WIND/SOLAR ENERGY GENERATION OVERLAY (WSE-O) PLAN (WSEO-17-001) FOR THE FRONT RANGE-MIDWAY SOLAR PROJECT

EL PASO COUNTY, COLORADO

WSEO Map V_1 attmnt 28 redlines.pdf Markup Summary 7-28-2020

**WSE-O PLAN (WSEO-17-001)**  
EL PASO COUNTY, COLORADO  
FRONT RANGE-MIDWAY SOLAR PROJECT  
PROPOSED SOLAR GENERATION MAP

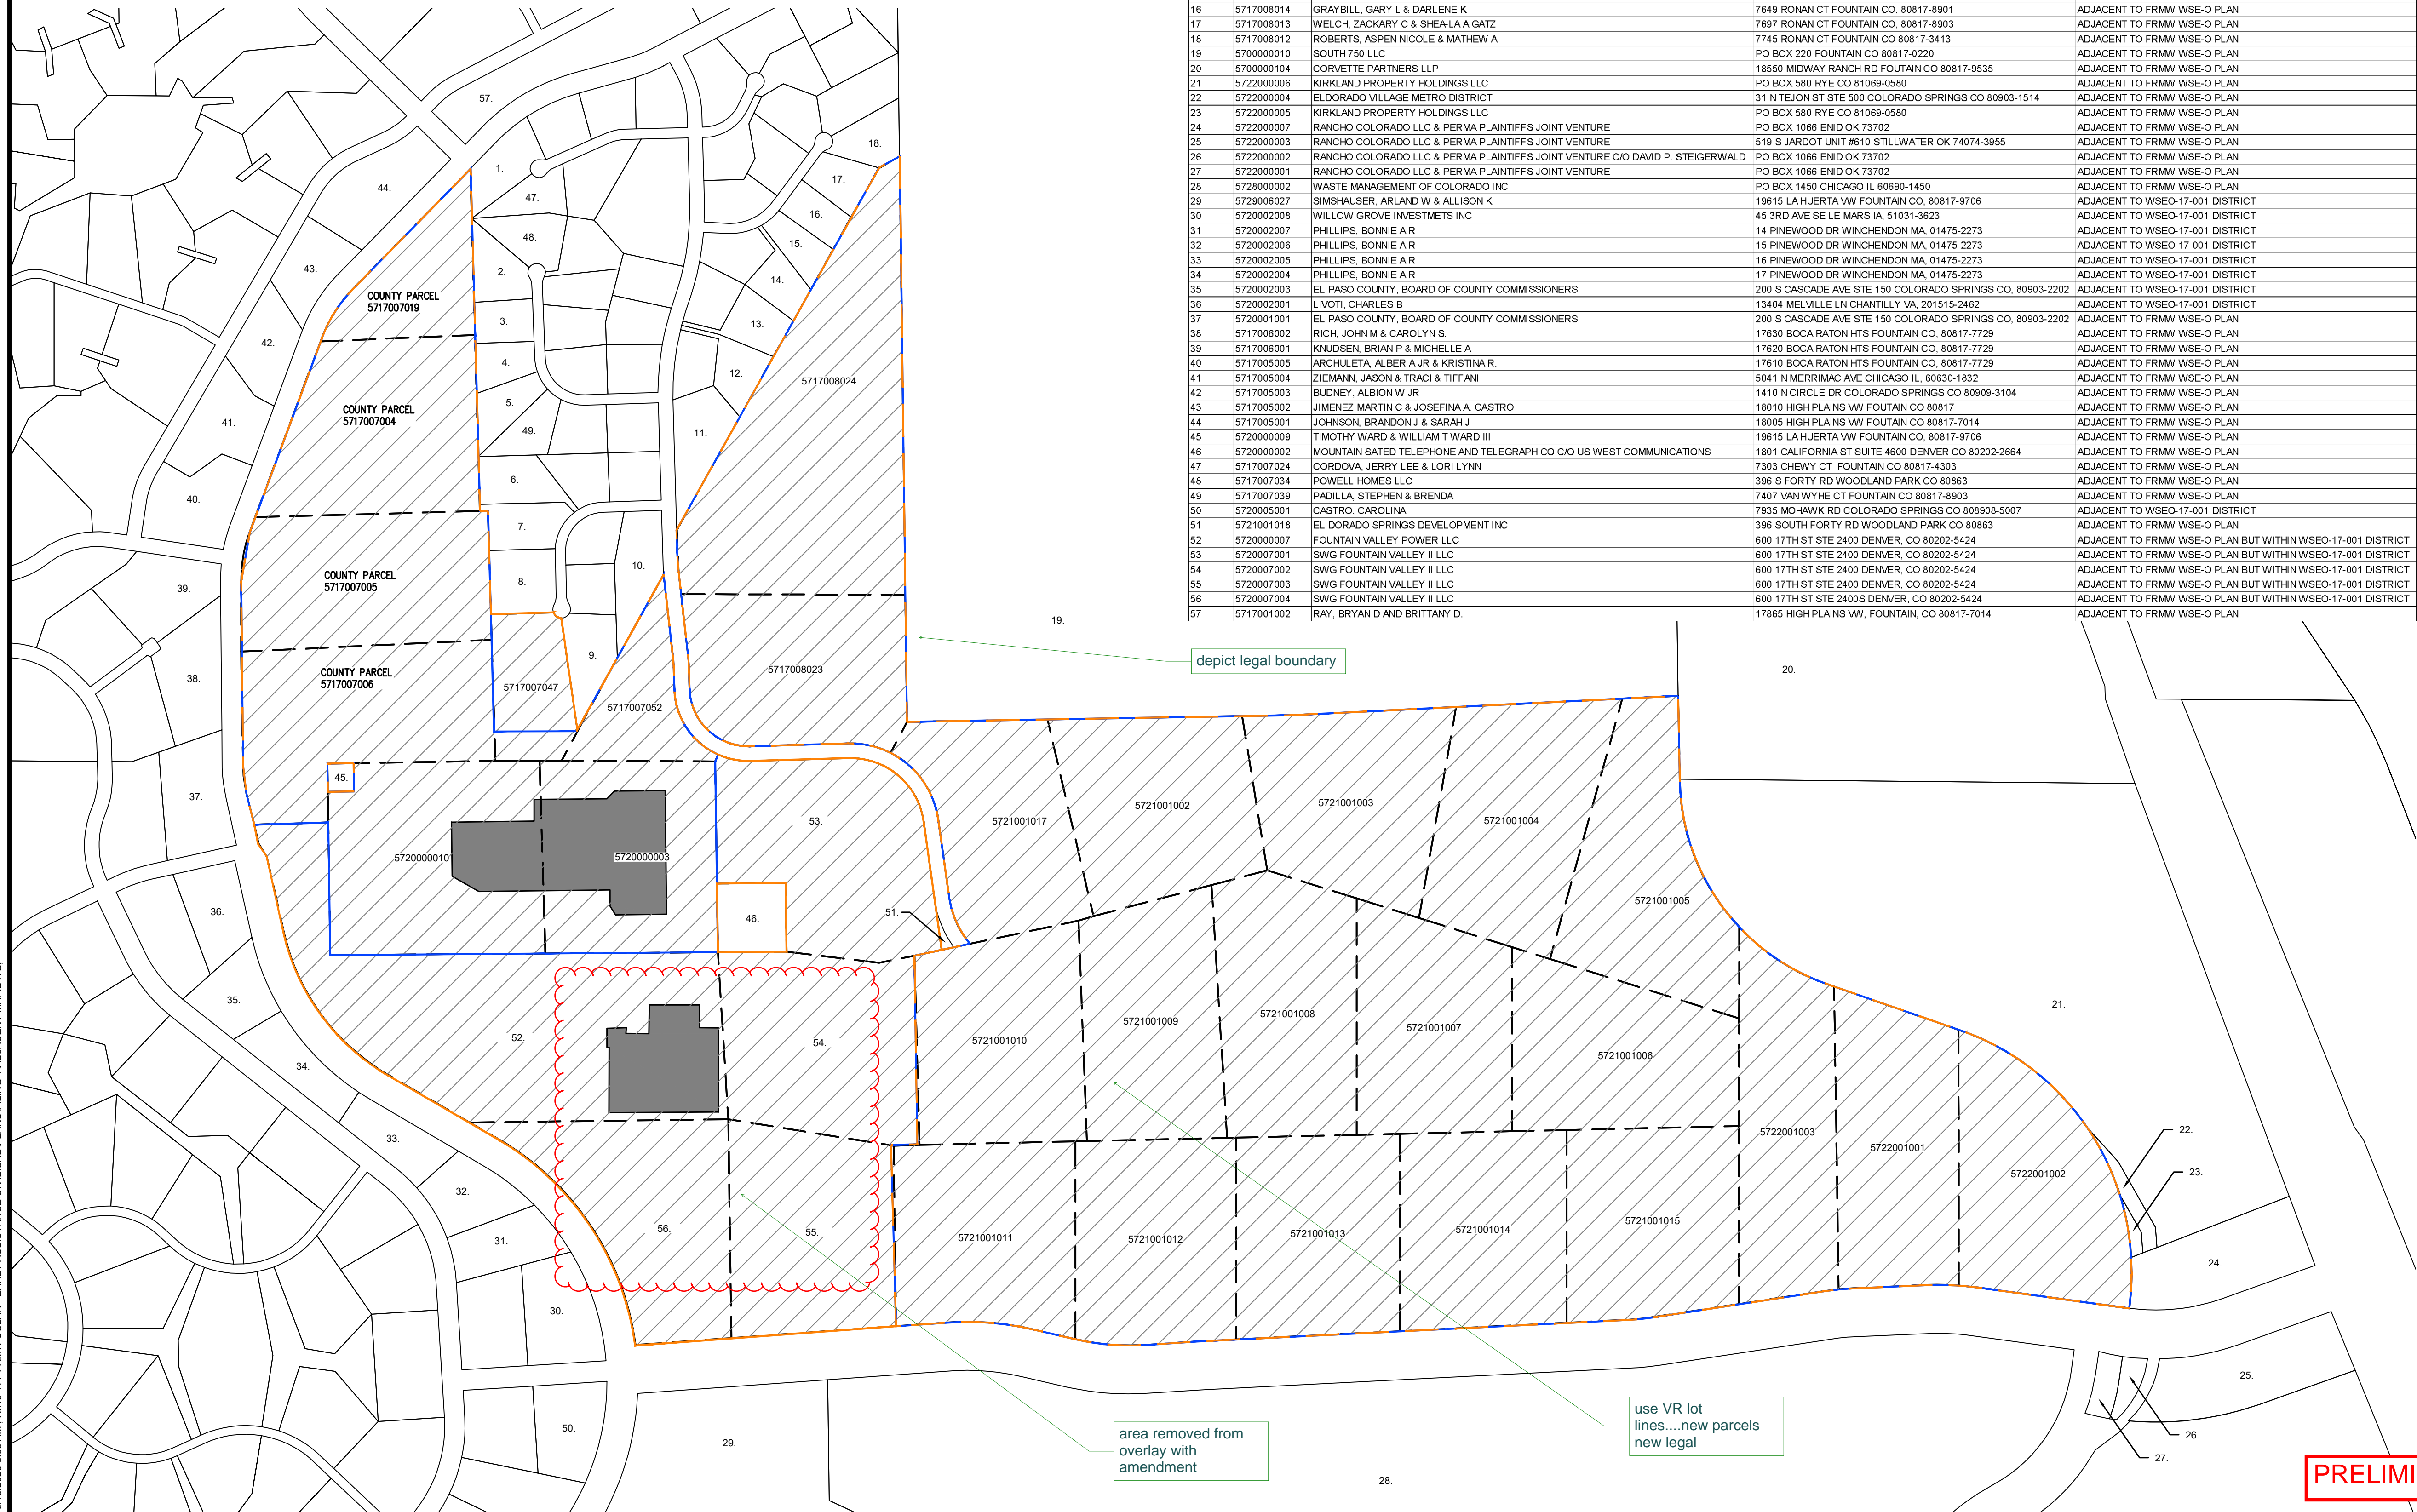
Add the elevations that changed and new buildings to the plan set also

AMENDMENT
Remove file number from title block

this is missing multiple sheets and sig blocks- this should look like the previous WSEO plan set except have changes

take the approved WSEo that was recorded and CLOUD the areas to be amended; remove the signatures and adjust boundary, all sheets need to be included

where are sheets 2-13?
